Gunnedah Solar Farm

SSD 8658
Response to Submissions

Photon Energy

29 June 2018

CANADIAN SOLAR AUSTRALIA  
GUNNEDAH SOLAR PROJECT

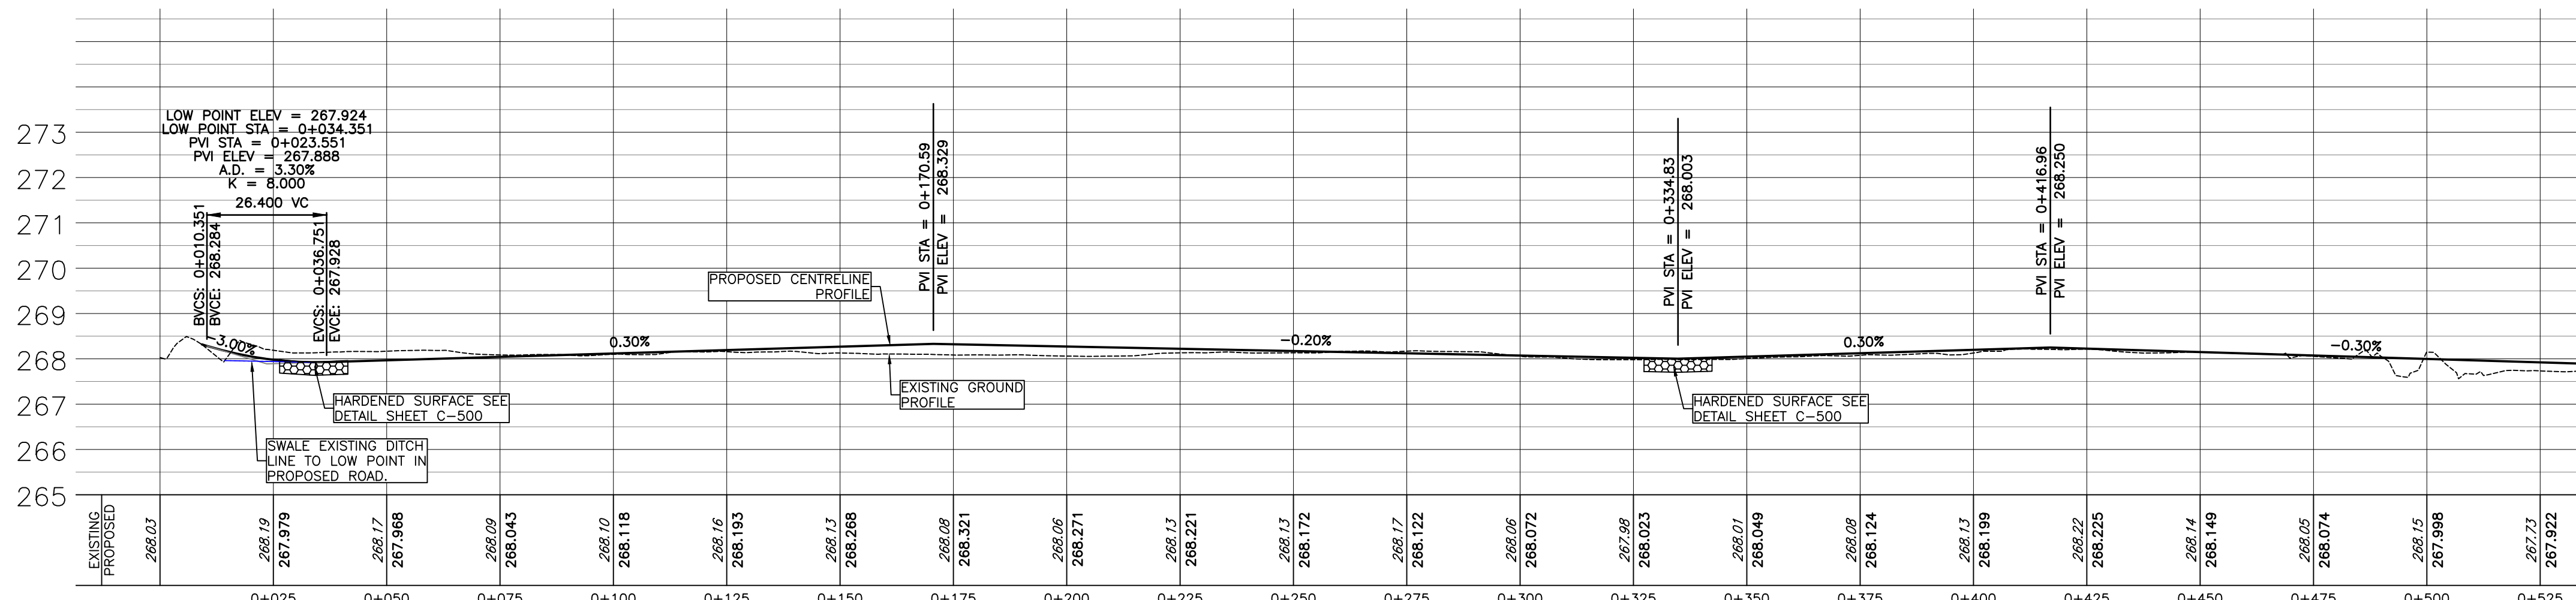
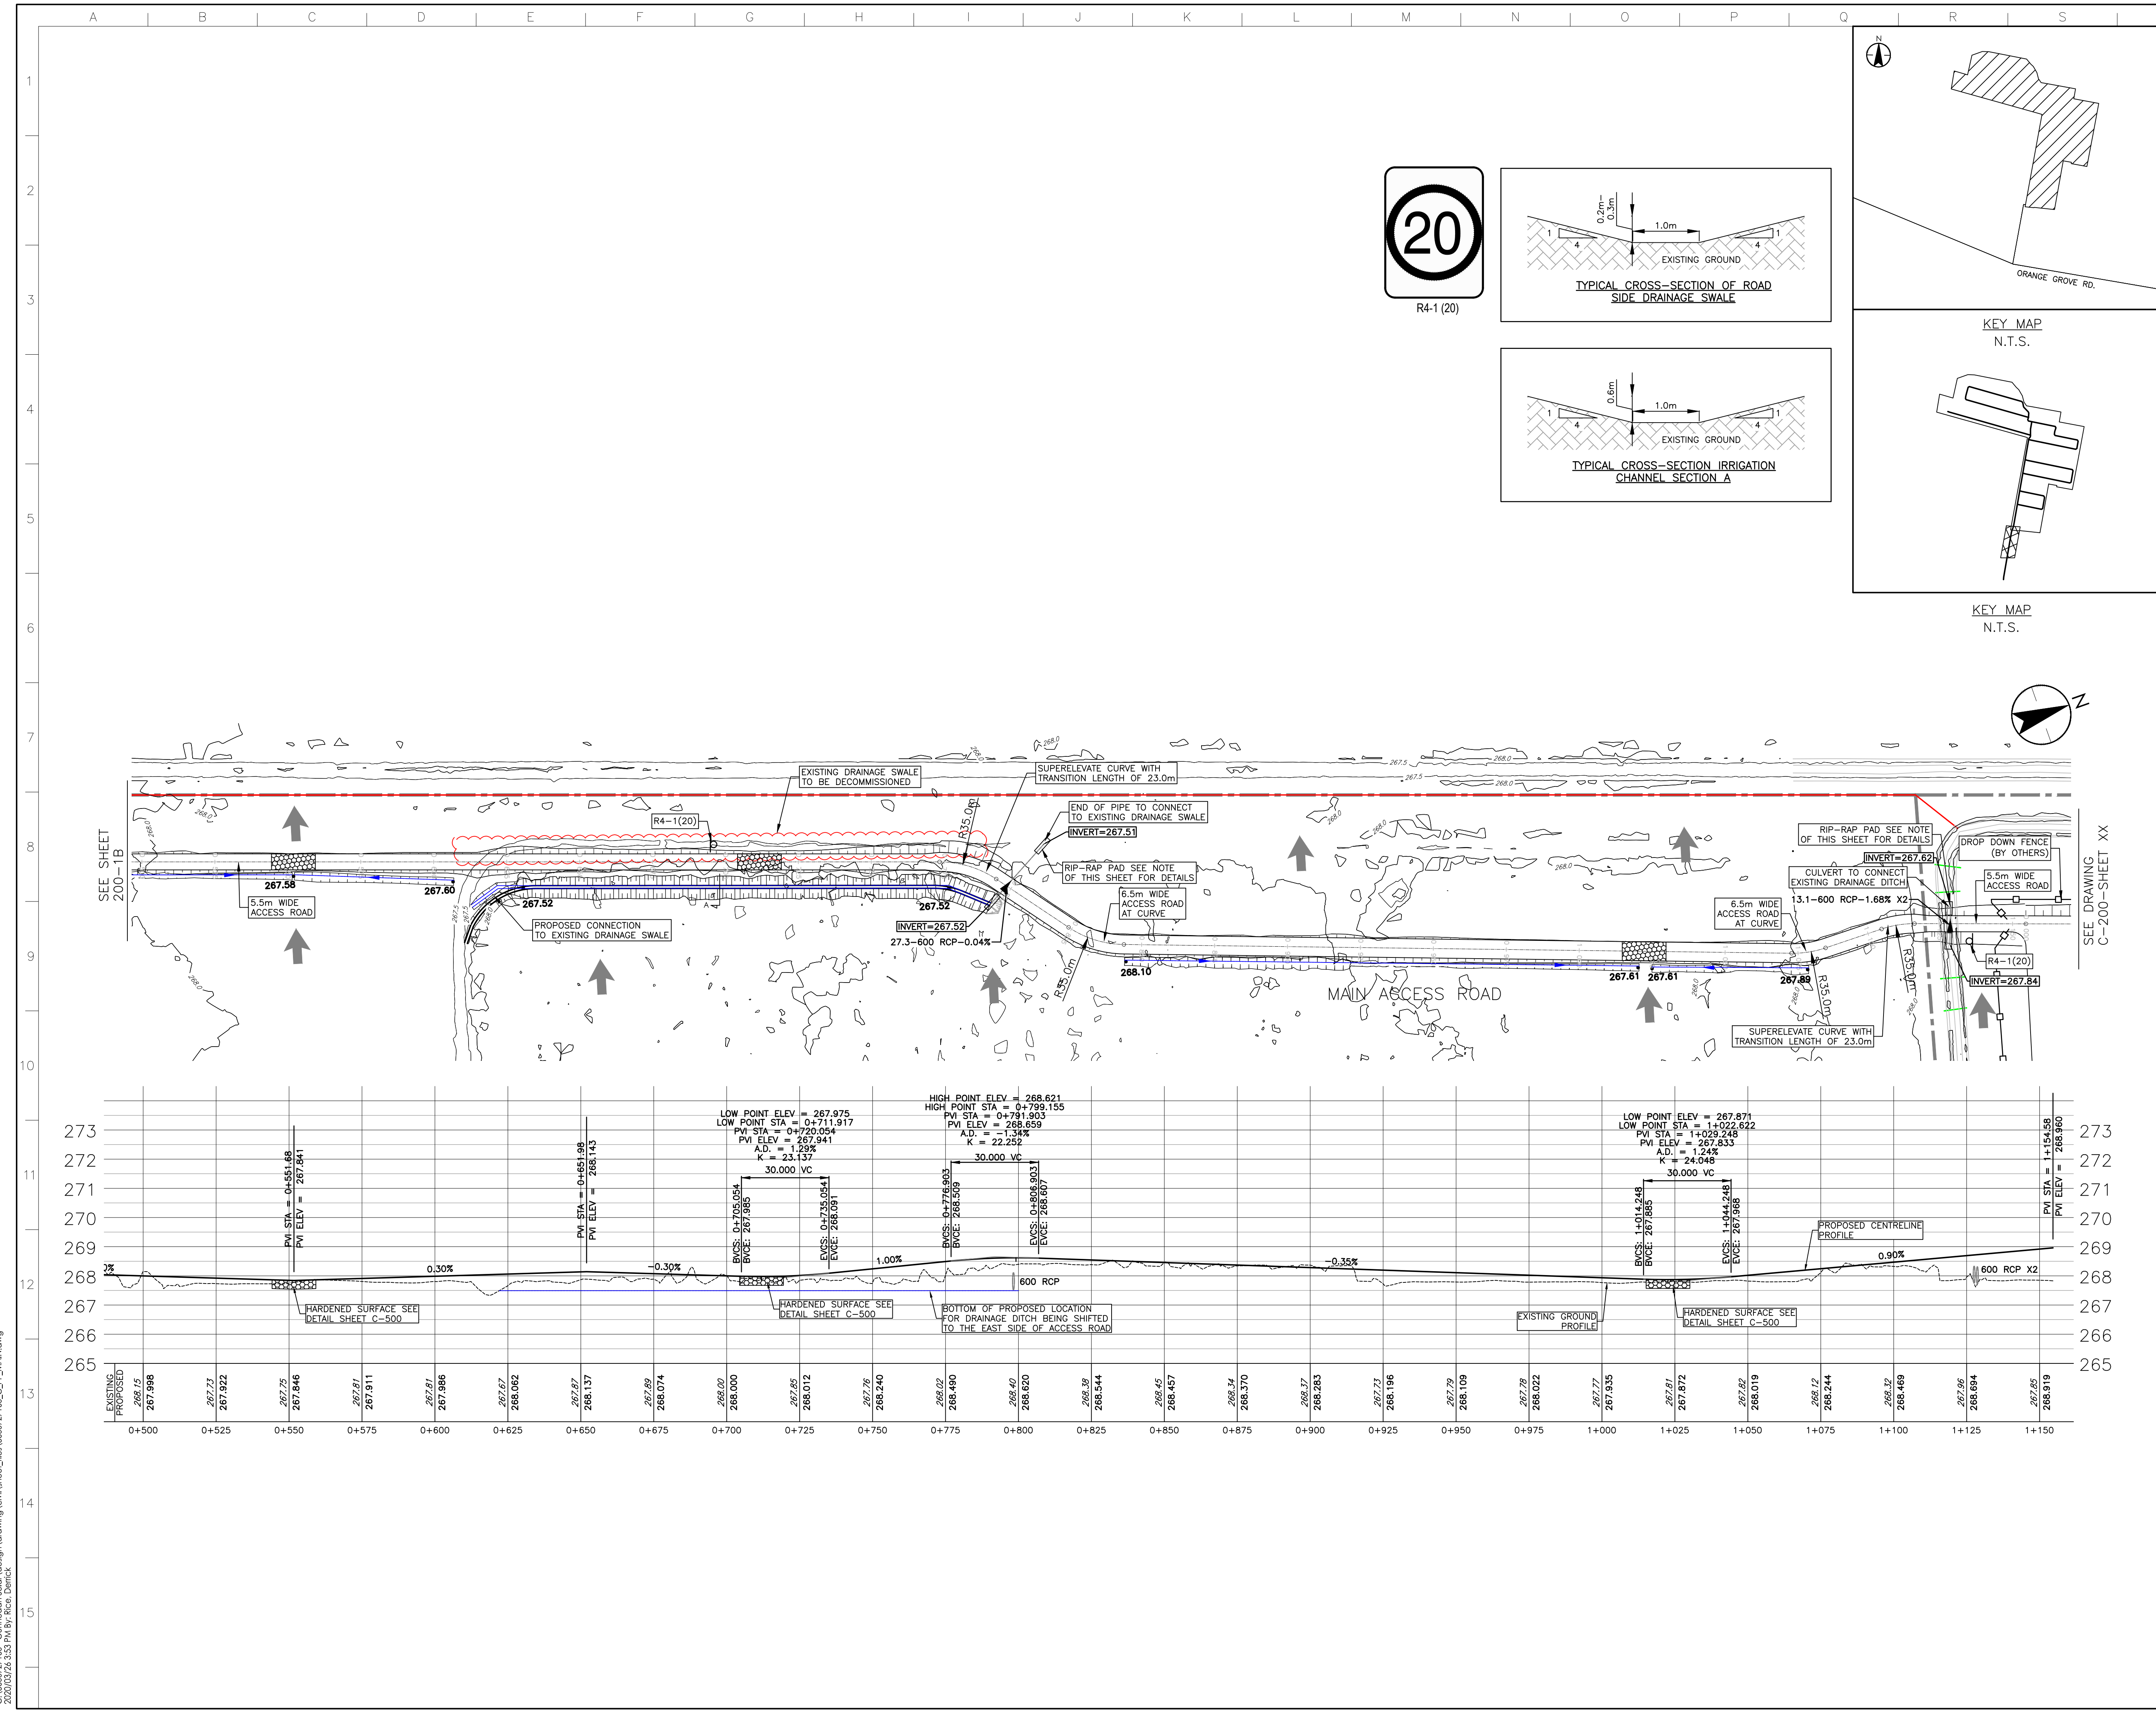
- Development and modelling of a new fence configuration to address concerns around impacts to flow from debris collecting on the proposed security fence. Fence Configuration 4 has been developed and involves drop-down fencing in key areas and represents an alternate approach to mitigating the effects of the fence on floodwaters.

A new fence configuration (referred to as Fence Configuration 4) has been developed and modelled as depicted in Figure 3-1, and further described in Appendix C. It represents an alternative fencing design aimed at minimising blockage and redirection of floodwater and the potential impacts of the Proposal on the surrounding landscape and residents during a flood event. Fence Configuration 4 incorporates drop down fencing in key areas. The model indicates that Fence Configuration 4 further reduces flooding impacts compared to the preferred fence configuration presented in Appendix J of the EIS (Configuration 3) and produces an entirely acceptable outcome that is compliant with the Carroll-Boggabri Flood Management Plan 2006 and have negligible flood impacts on surrounding properties.

GSF commits to construction of perimeter security fencing which is designed to allow flood water into and through the development site during significant flood events to minimise potential redirection of flood flows due to fence blockage. Design of the fencing shall seek to prevent offsite impacts in relation to flood levels and flood velocity, consistent with the complying works criteria in the Carroll to Boggabri Floodplain Management Plan 2006. The detailed design of the perimeter security fencing would be undertaken post consent and as part of construction certificate approval.
